**From:** Planning  
**Subject:** FW: Application 3/2020/0978 - Lower Standen Farm Pendleton  
**Attachments:** Lower Standen Hey Farm Location Map 2.pdf

**Application 3/2020/0978 (LBC)**  
**Lower Standen Farm Pendleton**

Application 3/2020/0978 (LBC)
Lower Standen Farm Pendleton

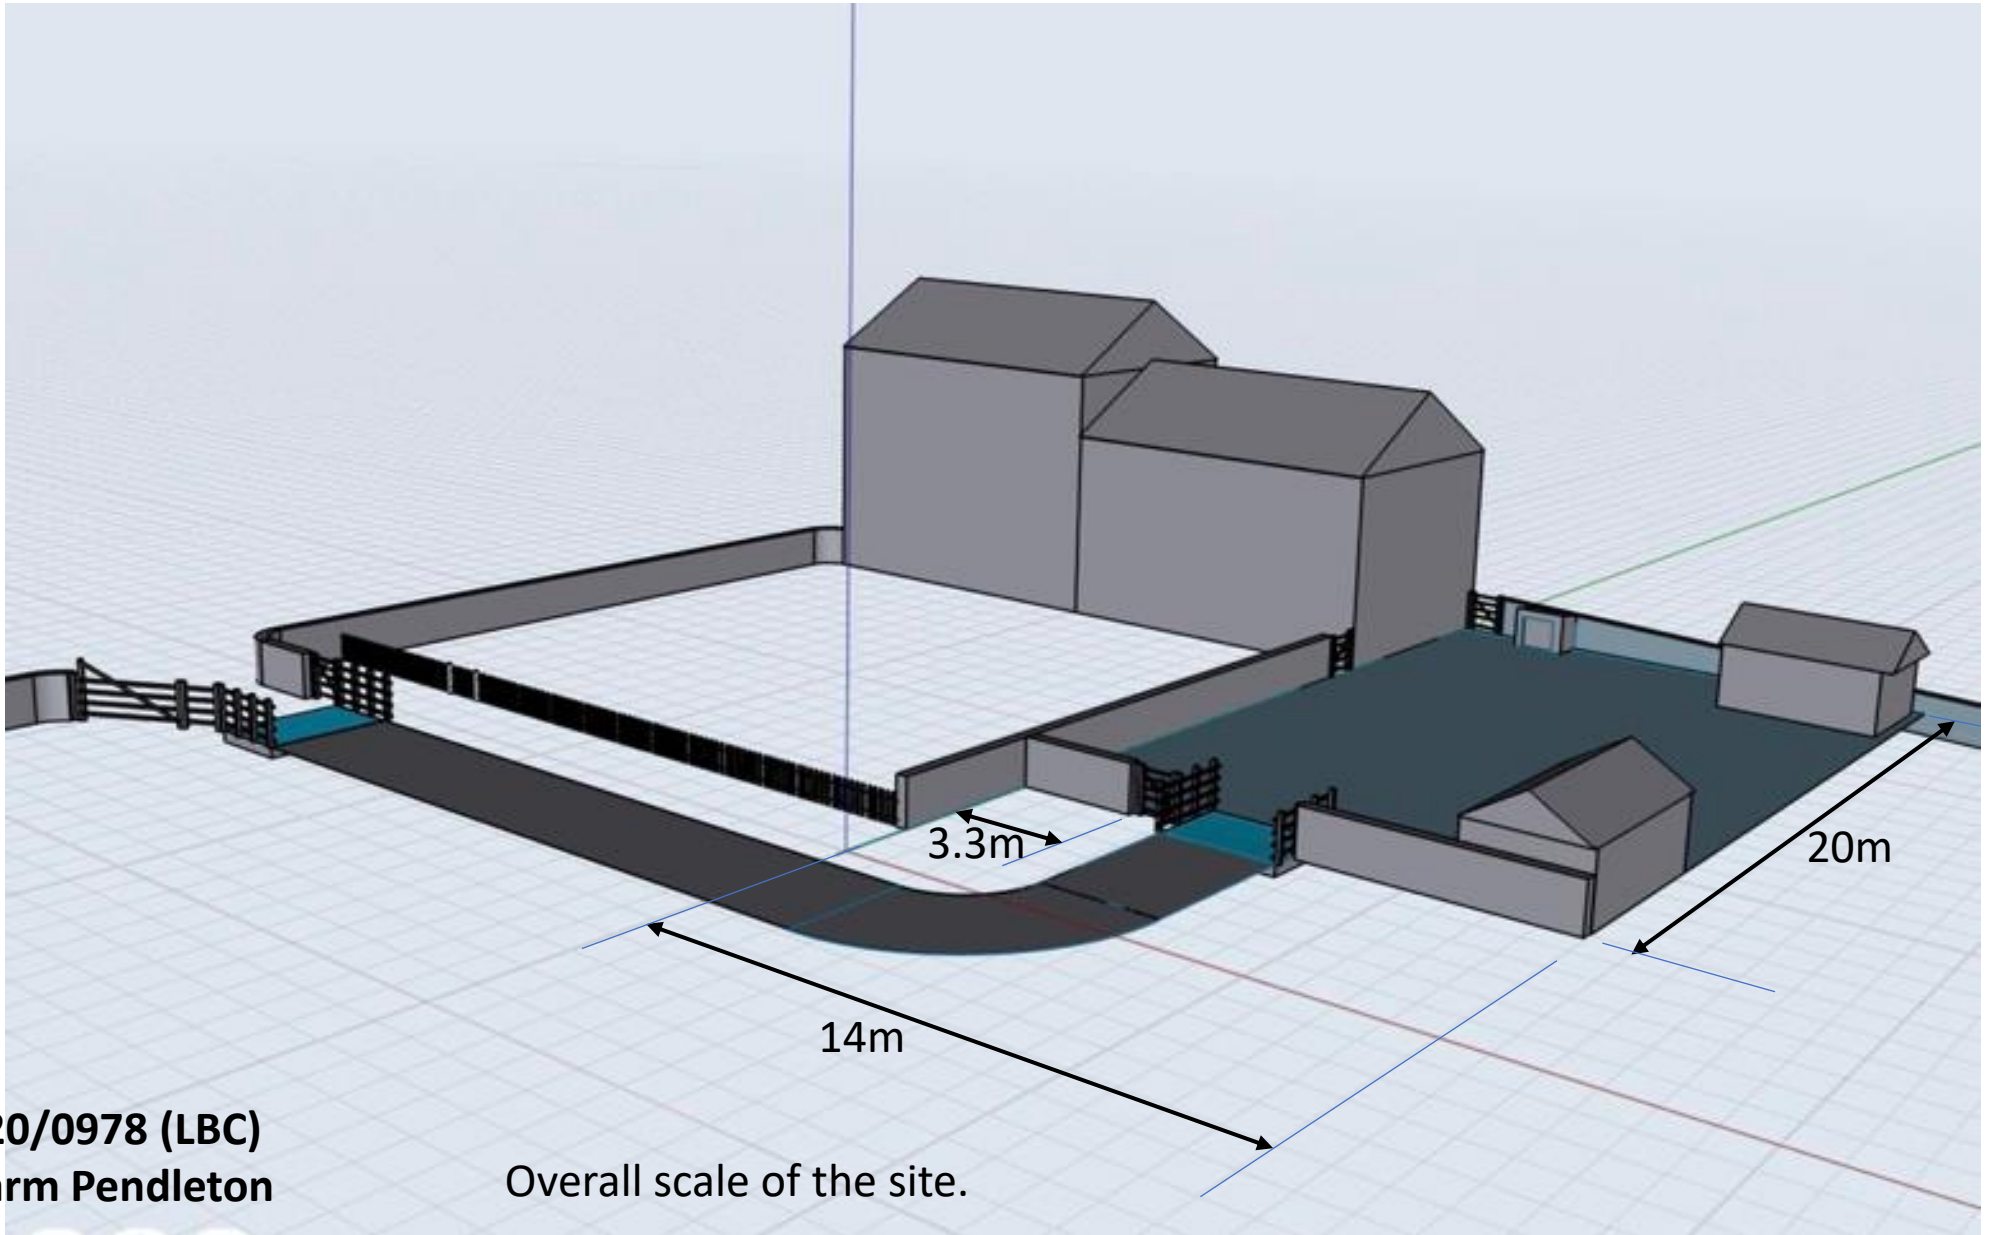
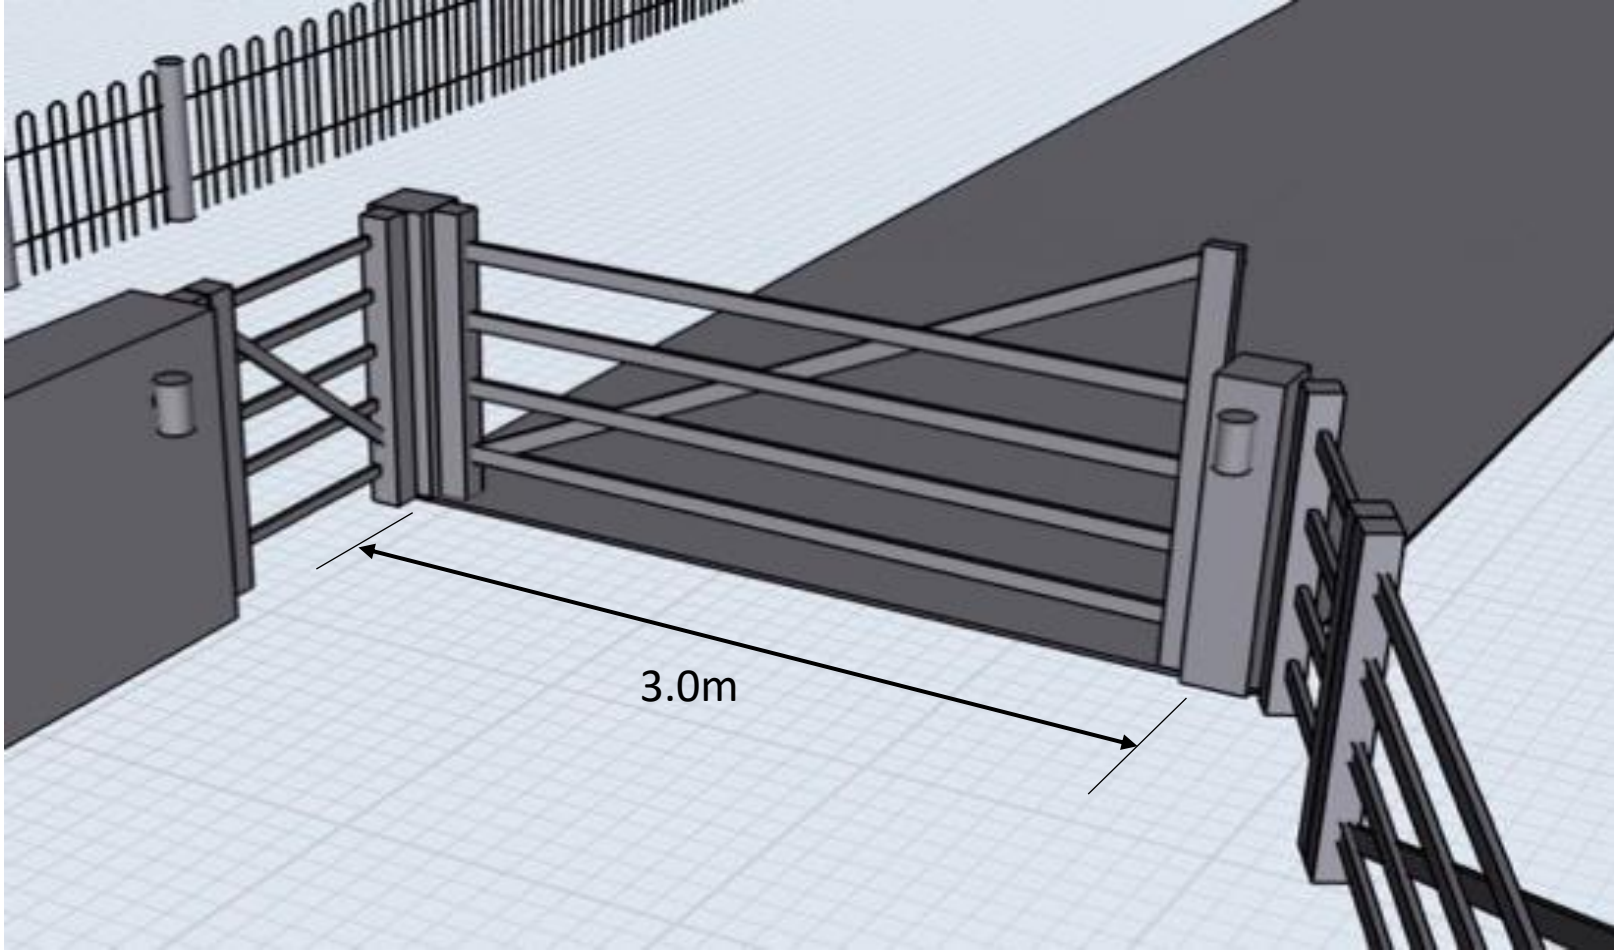
Section 7 of the Act identifies listed building consent requirements – please show (including relevant drawings or other information) how the proposed works demolish, alter or extend any part of the listed building.

The site plan has no north point or scale (in the form of a ratio).

The proposed works would not demolish any part of the listed building. The only "demolition" would be the removal of:

- The 2x cattle grids.
- The short lengths of post and rail wooden fencing immediately associated with these cattle grids.
- The 5-bar wooden pedestrian hand gate next to the hard standing (shown in the photo attached to the RHS of the cattle grid in the photo).

The only element of alteration to any stonework would be the addition of a short length of wall to replace the pedestrian hand gate referred to above.

2) I note your comment about the absence of a North indication on the Location Map I provided. I have attached an amended version of the Location Map that includes this North indication, though please note that there is a scale indication in the lower RH corner.
